From: Richard Hart [REDACTED]
Sent: 03 December 2020 21:33
To: Planning <Planning@arun.gov.uk>
Subject: Fwd: Objection to Planning Application - AB/114/20/PD

Objection to Planning Application

AB/114/20/PD
Riverside House

2 Fitzalan Road
Arundel
BN18 9JS

Drawing Title:
PROPOSED PLANS

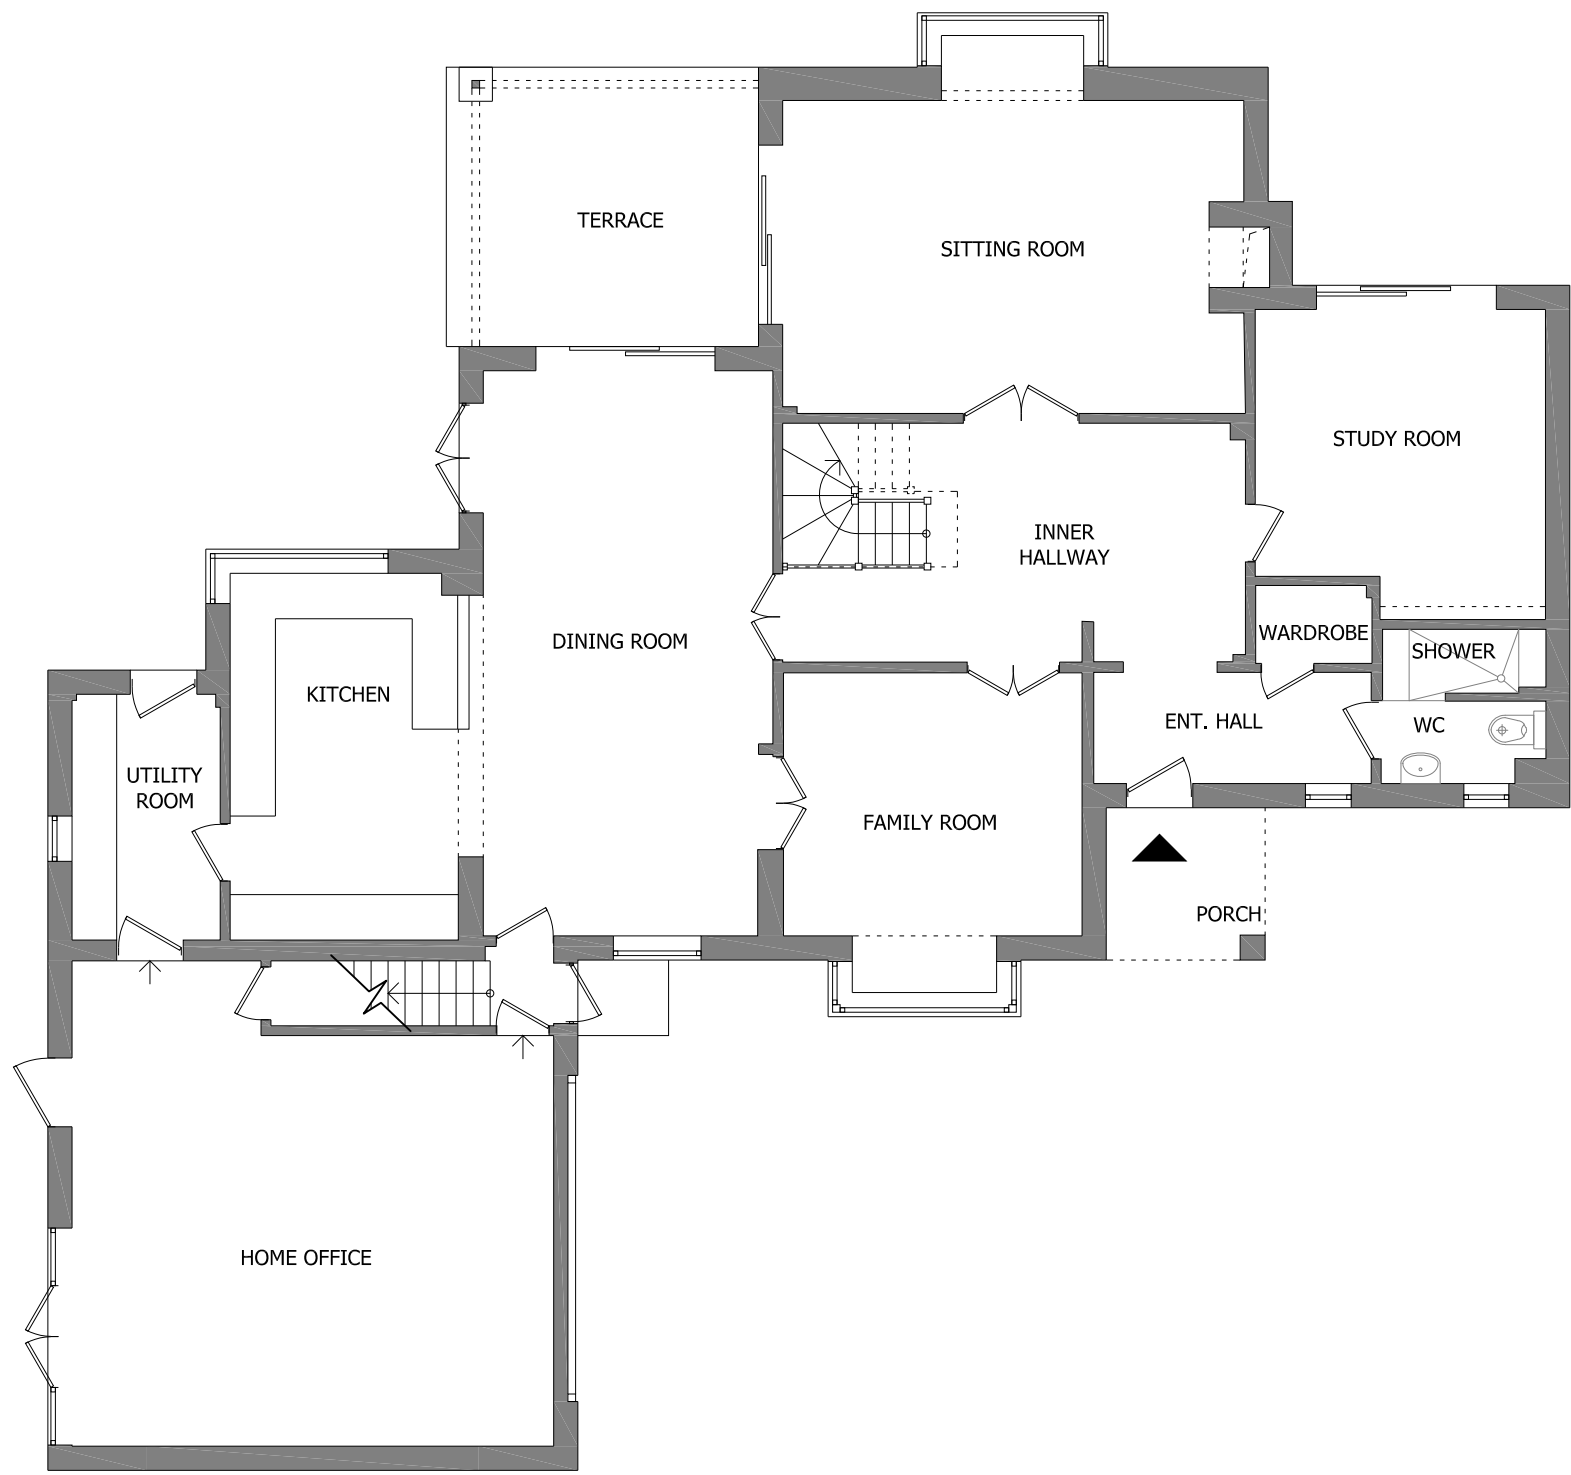
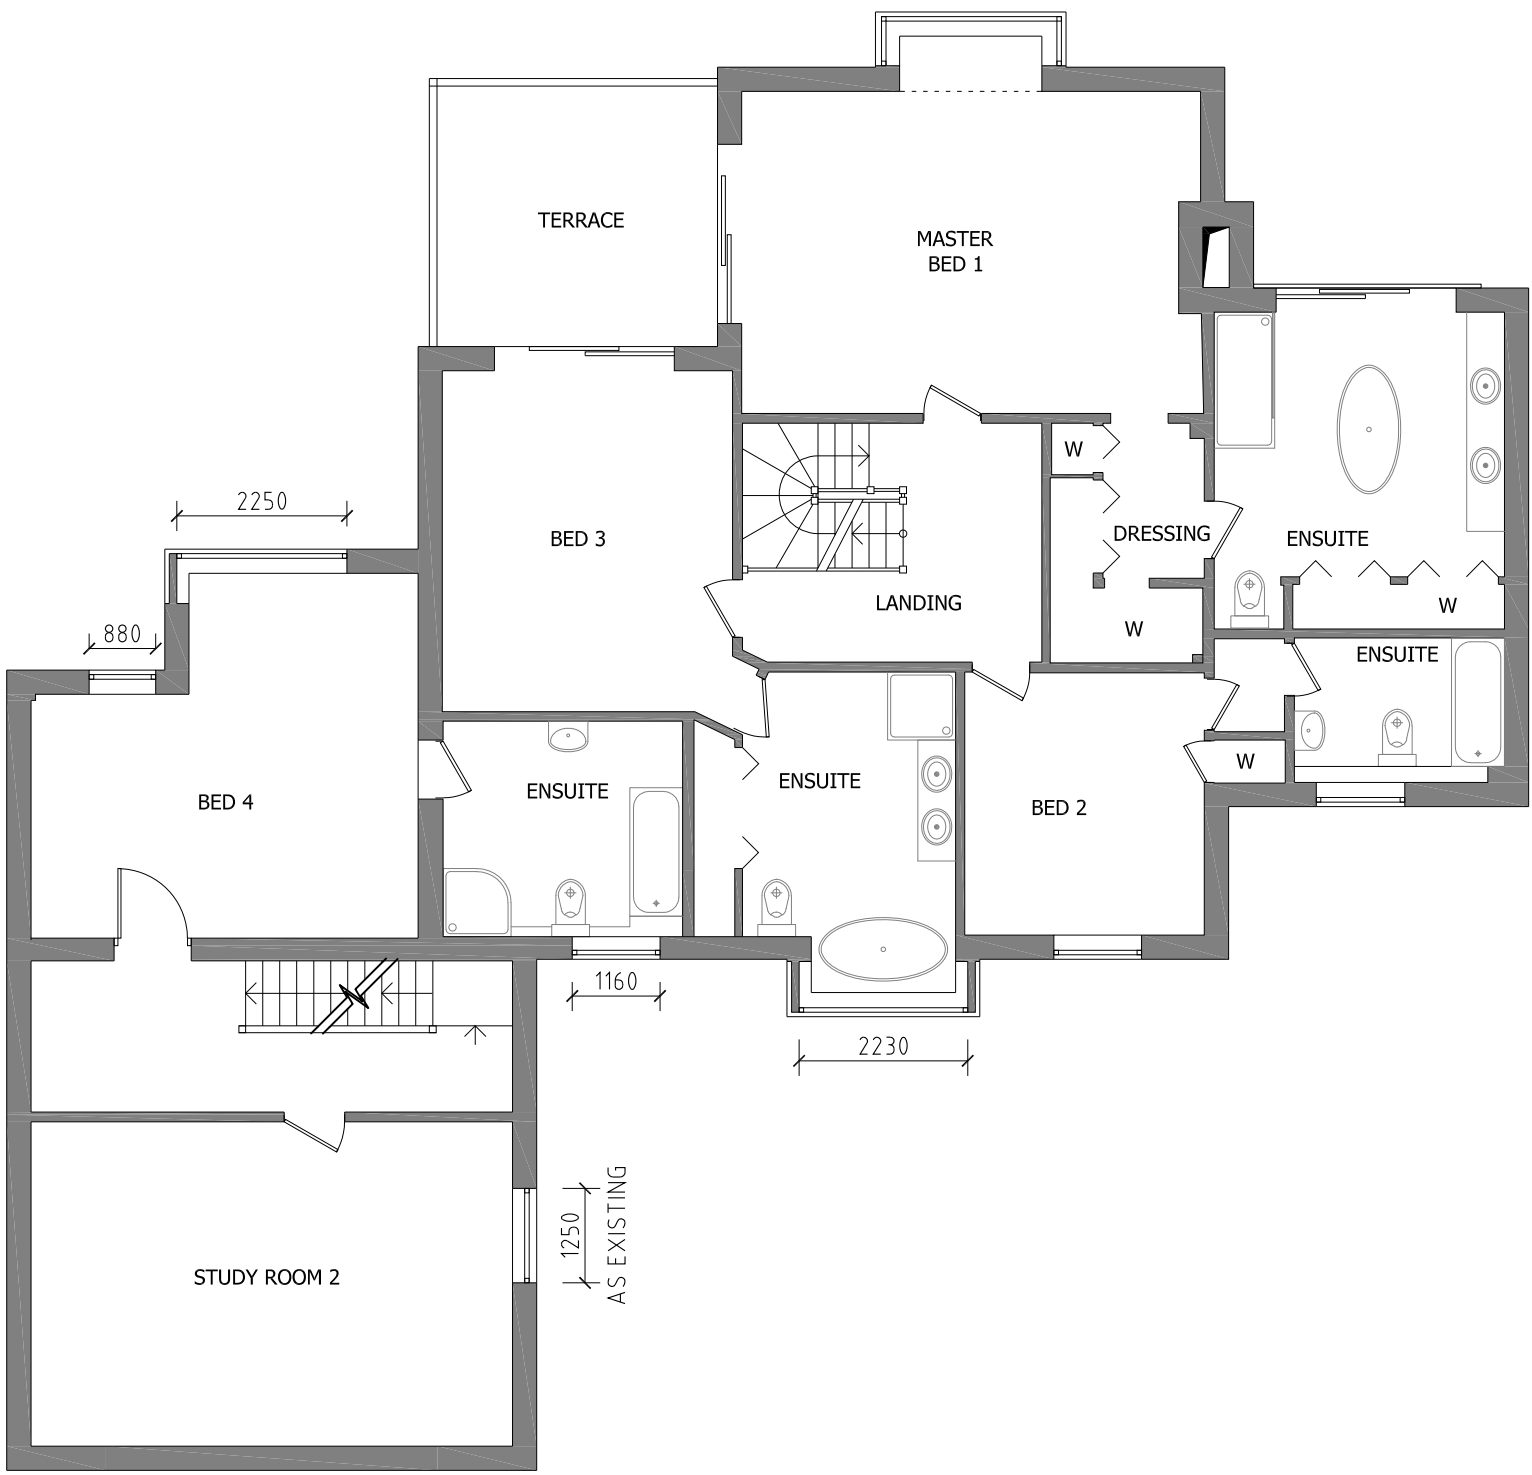
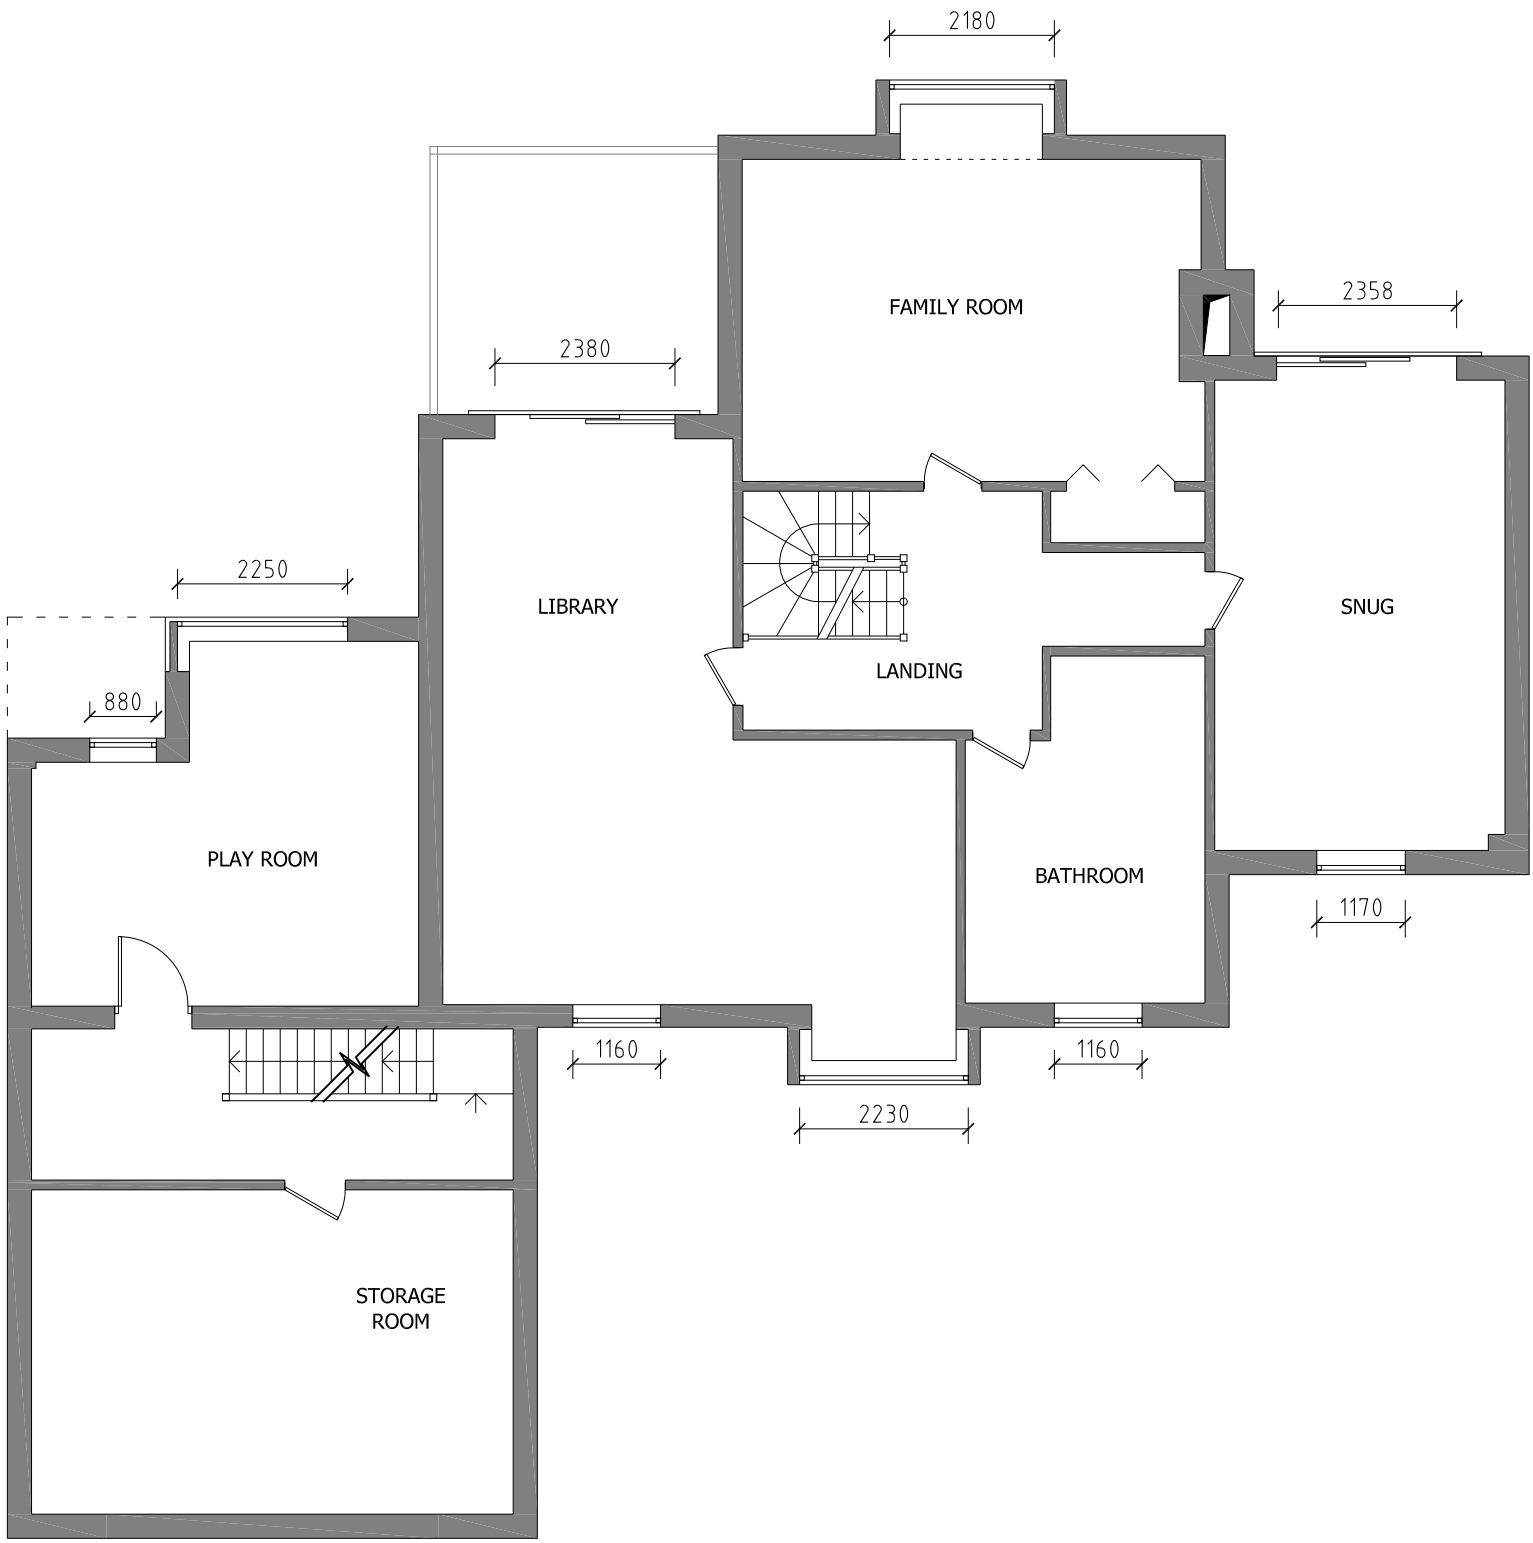
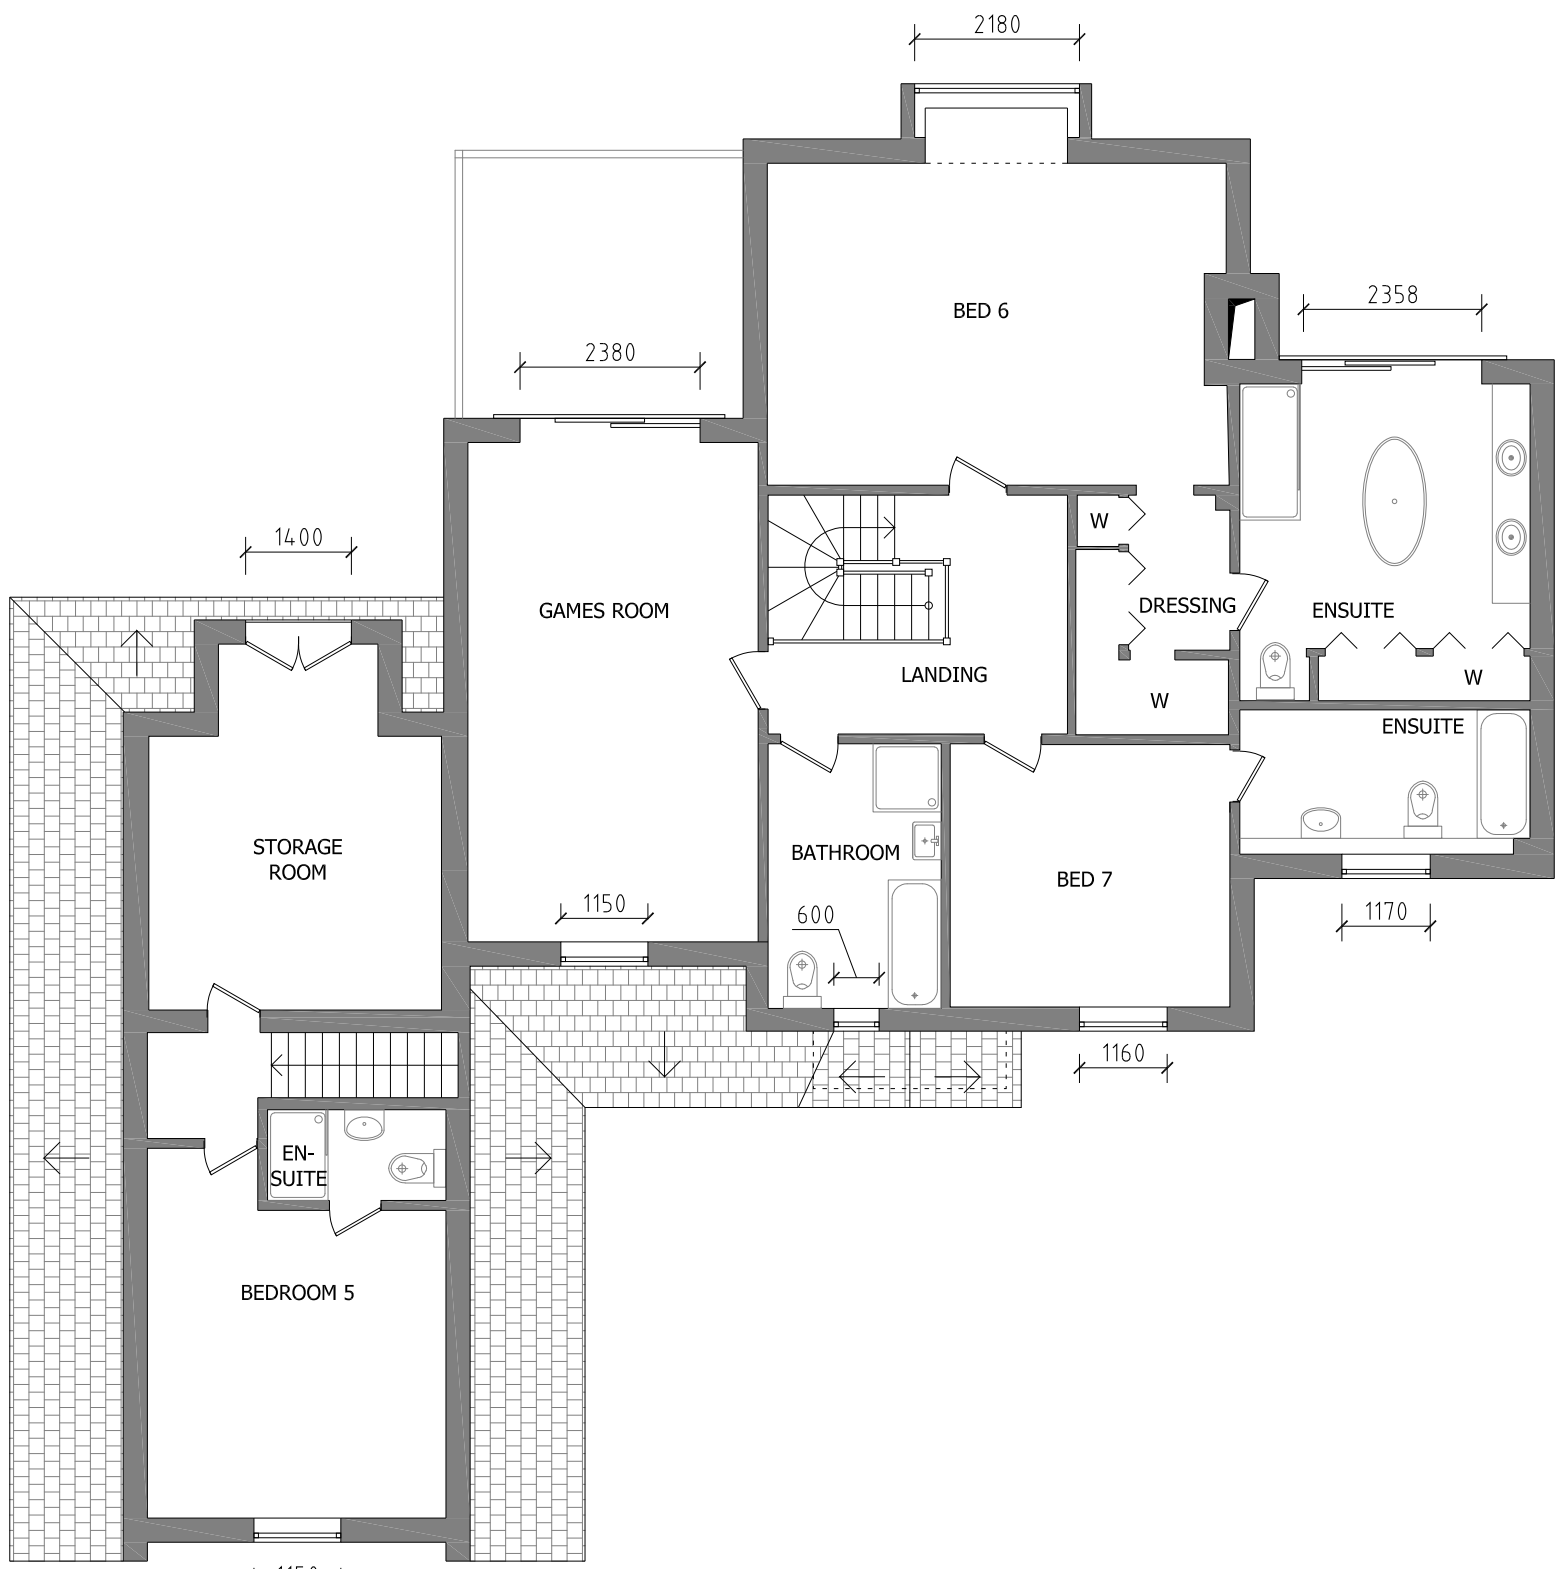
3. The proposed elevation will obscure the view into and out of the Arundel Conservation Area, much to its detriment.
4. I note from the plans that there are some eleven proposed bathrooms, the future intent for which is surely a multi-occupancy dwelling of several flats. If this is indeed the case it should be declared as such, and not become an example of incremental development by stealth. If the intent is for a multi-occupancy building then parking requirements should be appropriately scaled, and the increase in traffic taken into consideration at this stage of the planning application.
